# WRITTEN REPRESENTATION FOR SPR EA1N and EA2 PROJECTS (DEADLINE 1)

## LAND USE

**Interested Party:** SASES    **PINS Refs:** 20024106 & 20024110

**Date:** 1 November 2020

East Anglia ONE North and TWO Outline Operational Drainage Management Plan Agricultural Land Classification

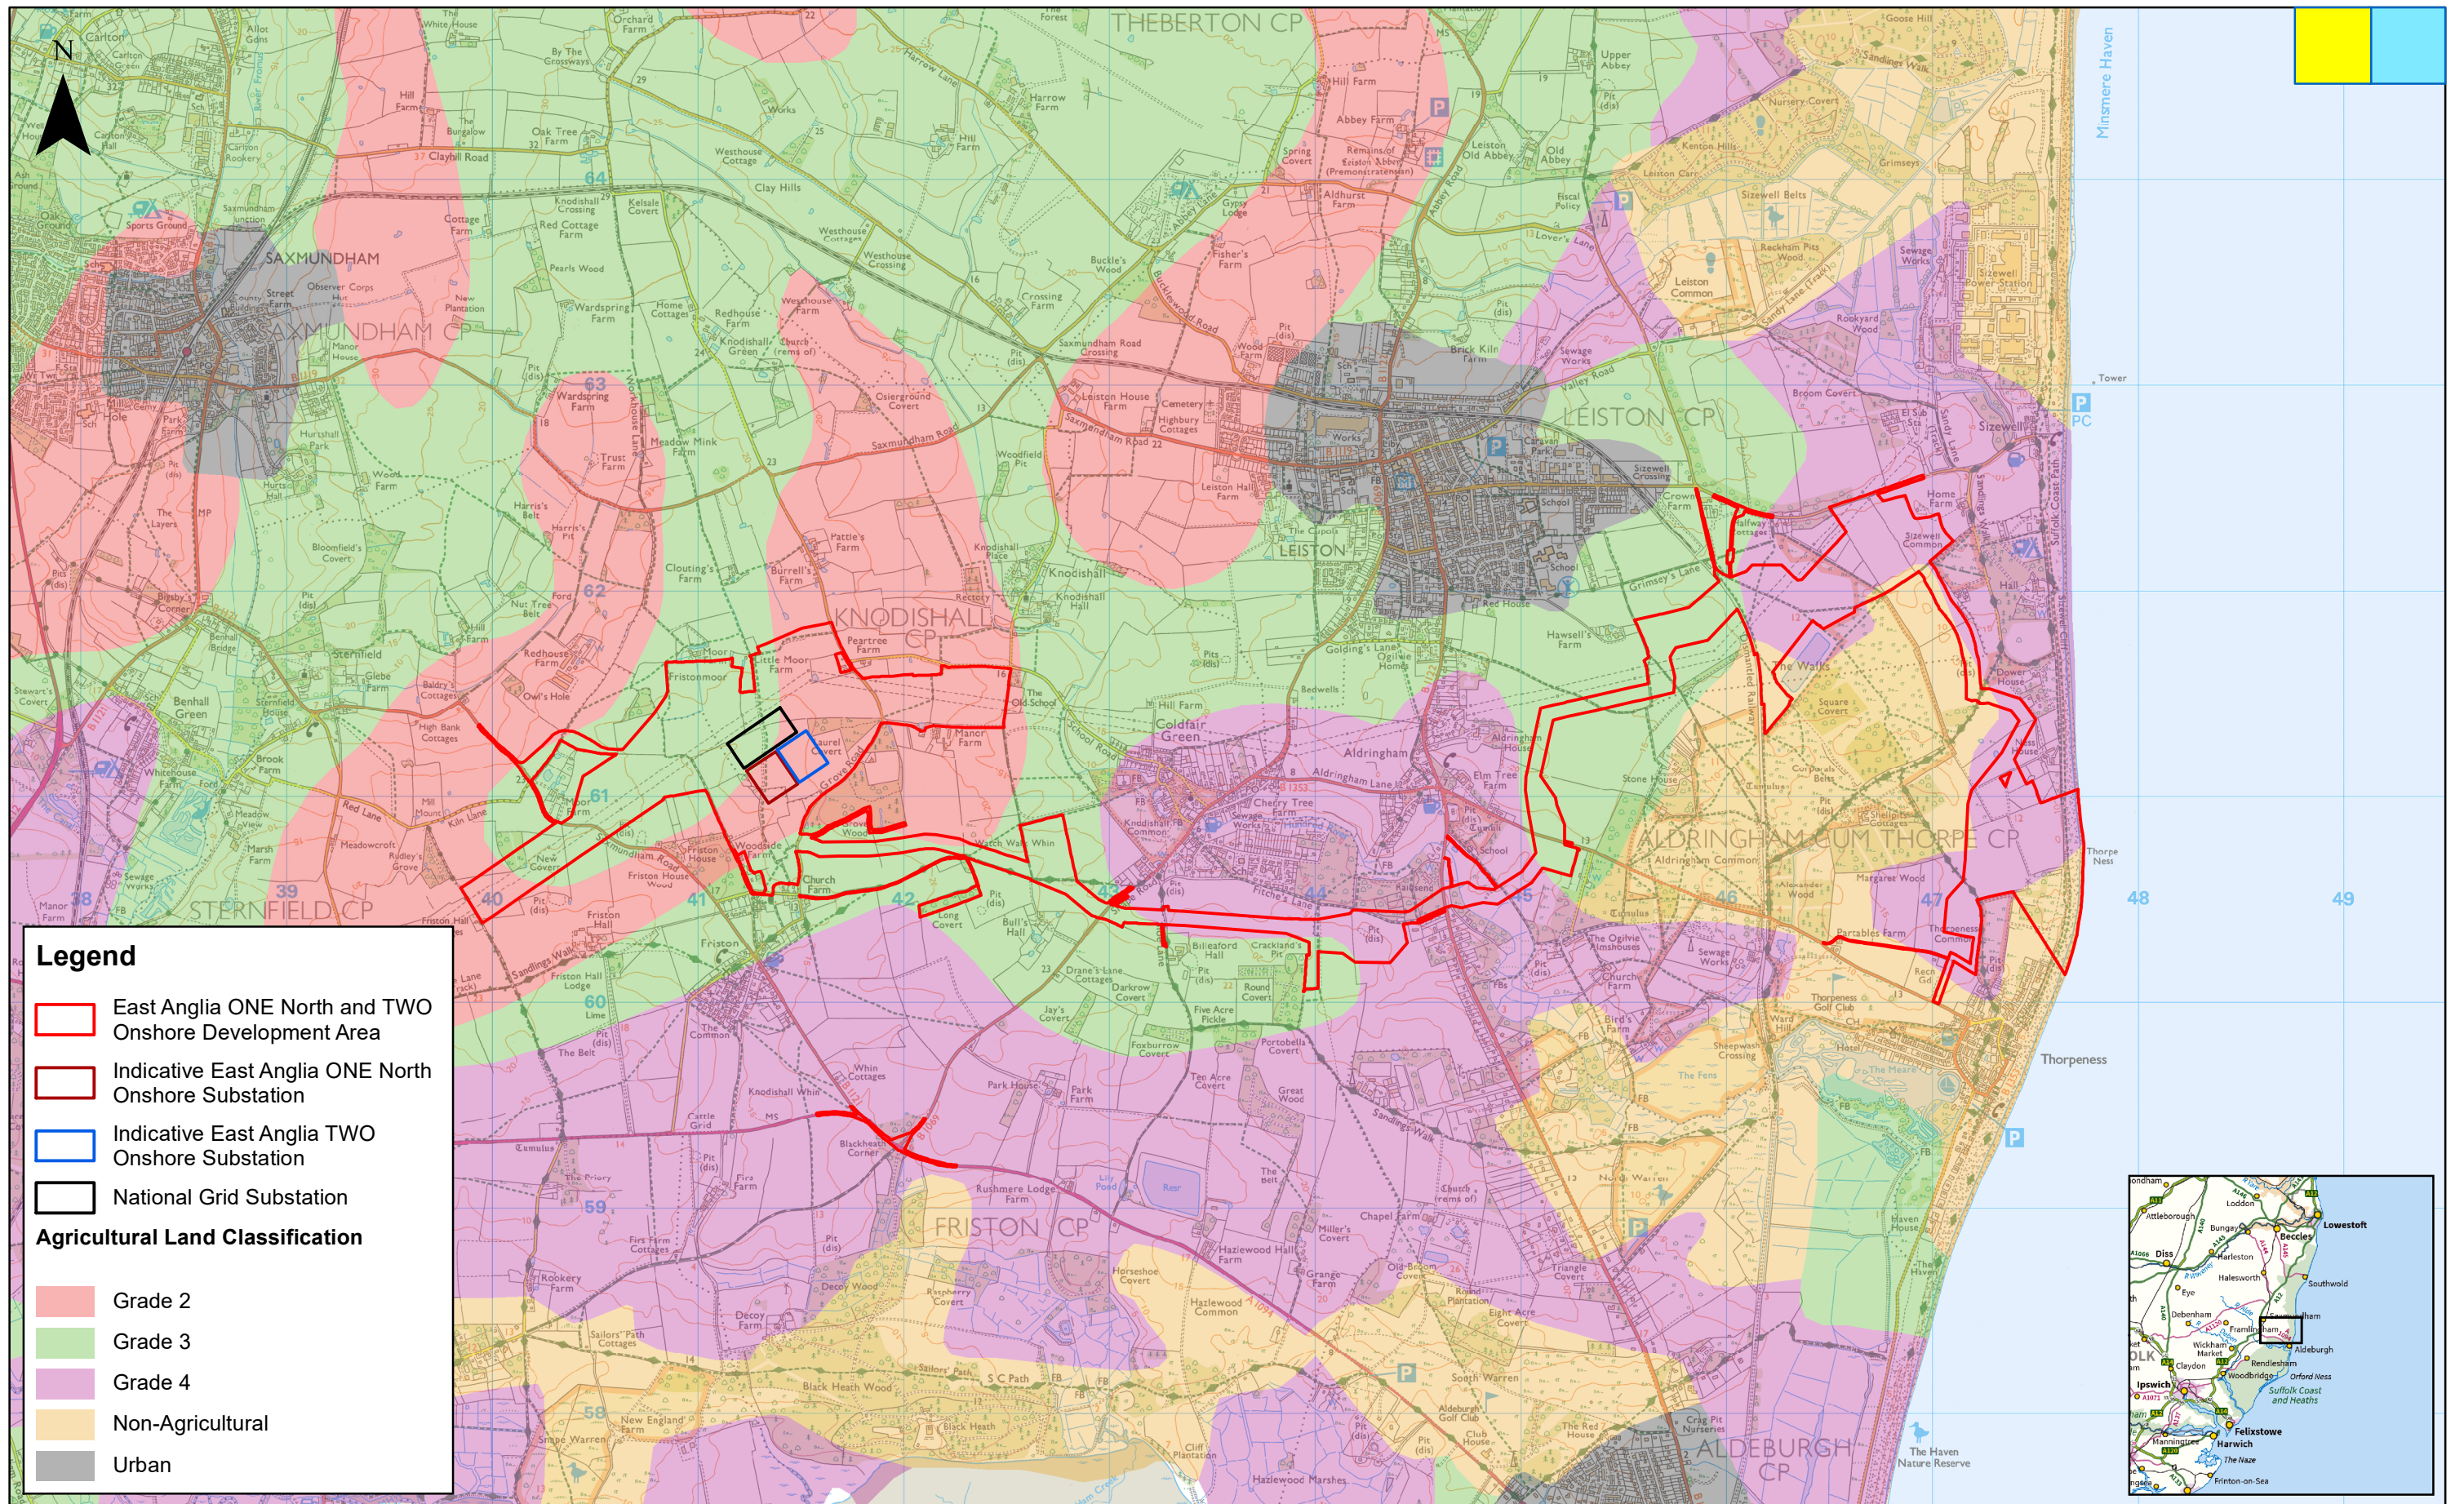
10. SPR have submitted a map of Agricultural Land Classification at 6.2.21.3 – Figure 21.3. Below is a detail of this map showing the substation site. The land coloured **pink** being Grade 2 and the land coloured **green** being Grade 3. Given that the green land (grade 3) is sited between two areas of Grade 2 land (pink) and also grows the same crops (cereal and beet), it is reasonable to assume that the green land is Grade 3a agricultural land.

It can be seen from this map that EA2 is 100% in grade 2 land, EA1N is approximately 98% in grade 2 land and that the NG substation is approximately 80% grade 3 and 20% grade 2. Any extension of the NG connection hub to the east to accommodate other projects would be 100% grade 2 land.
